From: Amanda Scholes on behalf of Planning.Responses
Sent: 14 January 2021 10:55
To: Planning Scanning
Subject: FW: Planning Consultation on: FG/153/20/DOC
Attachments: 201111 4000-5999 Series.pdf; 001497-JPL-ZZ-XX-DR-D-4100-S2-P03 Quercus Nursery Drainage Layout.pdf; JDI01497-JPL-ZZ-XX-DR-D-4000-S2-P01 Quercus Nursery Catchment Plan.pdf; QSE Greenhouses.pdf; 201112 MPW LLFA Drainage Strategy.pdf; J14325 Report.pdf; 201112 Surface Water Drainage Proposal Checklist - Completed.pdf

We do not recommend discharge of Condition 2 at this time, and have the following comments:

Application No: FG/153/20/DOC
Registered: 23rd November 2020
Site Address: Quercus Nursery Littlehampton Road Ferring BN12 6PG
Description of Works: Approval of details reserved by condition imposed under ref APP/C3810/W/19/3232525 (FG/35/19/PL) relating to Condition No 2 - surface water drainage.

PROPOSED DRAINAGE LAYOUT
AND DETAILS

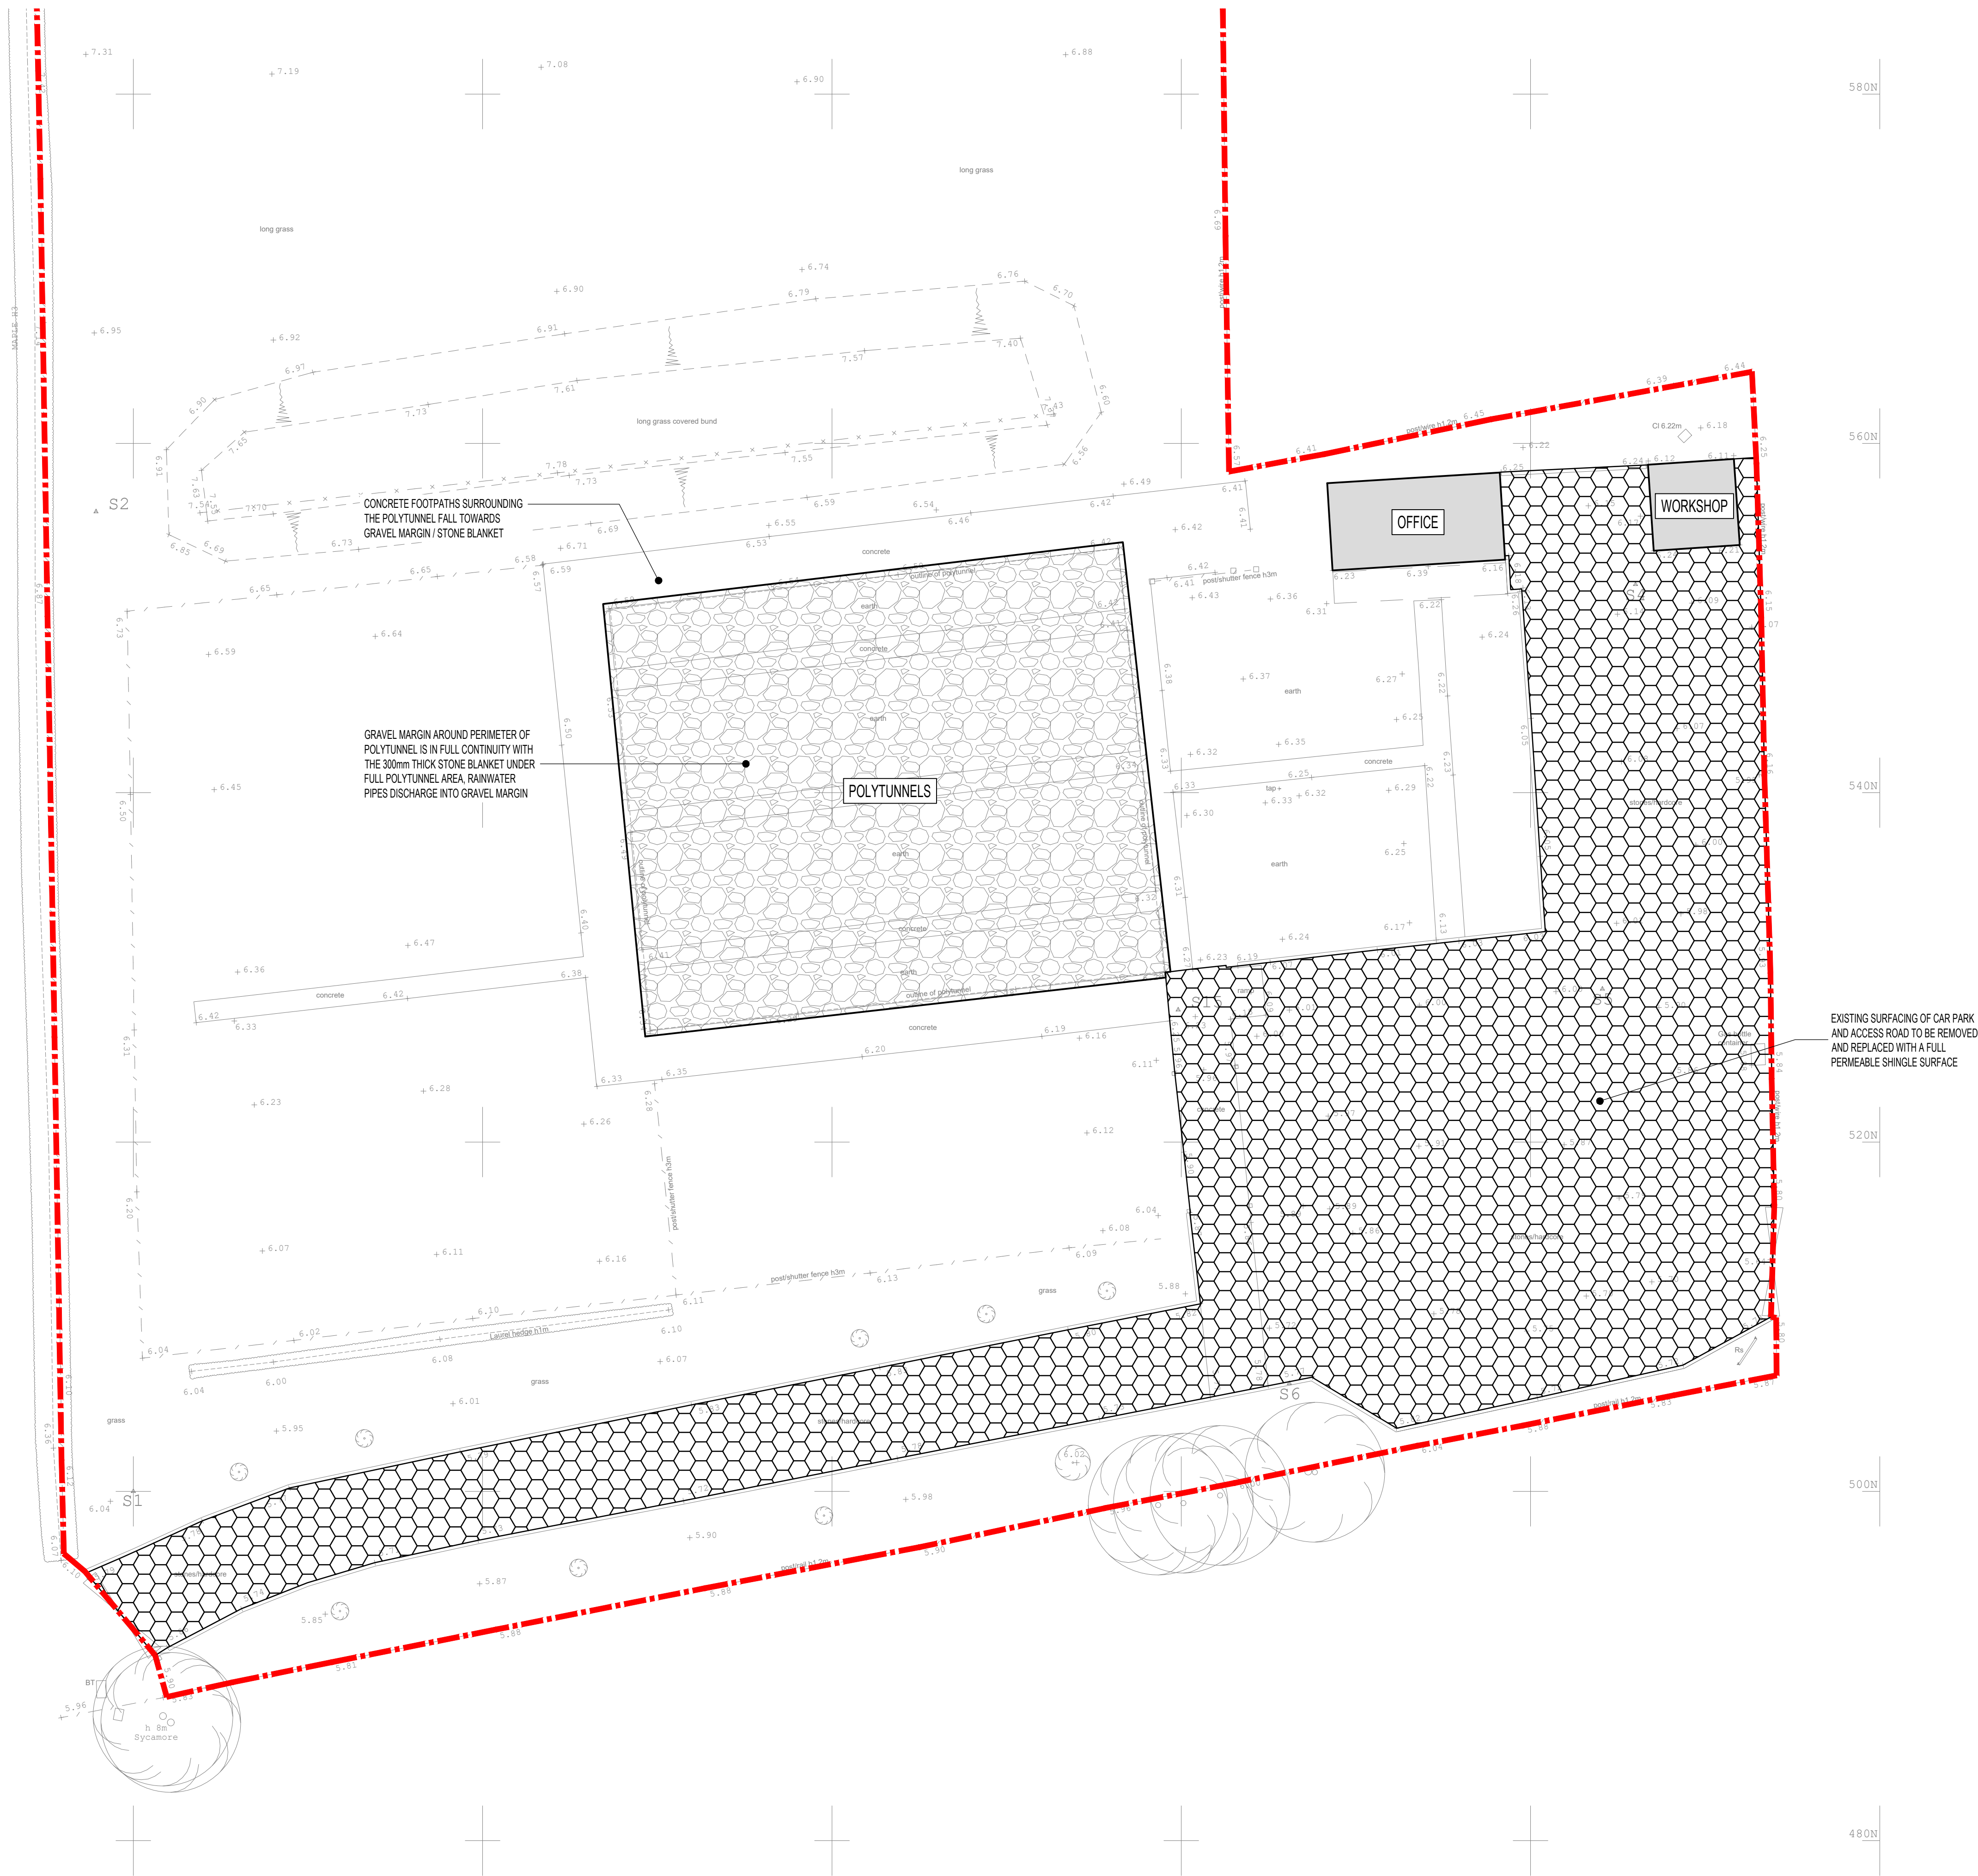
1. Infiltration testing was completed too deep and not in accordance with BRE365. One test was completed in each location only, and water failed to drain to 25% level. The infiltration tests were completed below groundwater level and not at the depth of the proposed infiltrating features.
2. No calculations have been supplied to support the design.
3. No construction detail drawings have been provided.
4. The layout plan does not detail the required depth of the car park sub-base.
5. The layout plan needs to clearly state whether permeable storage areas are to have flat sub-bases or not.
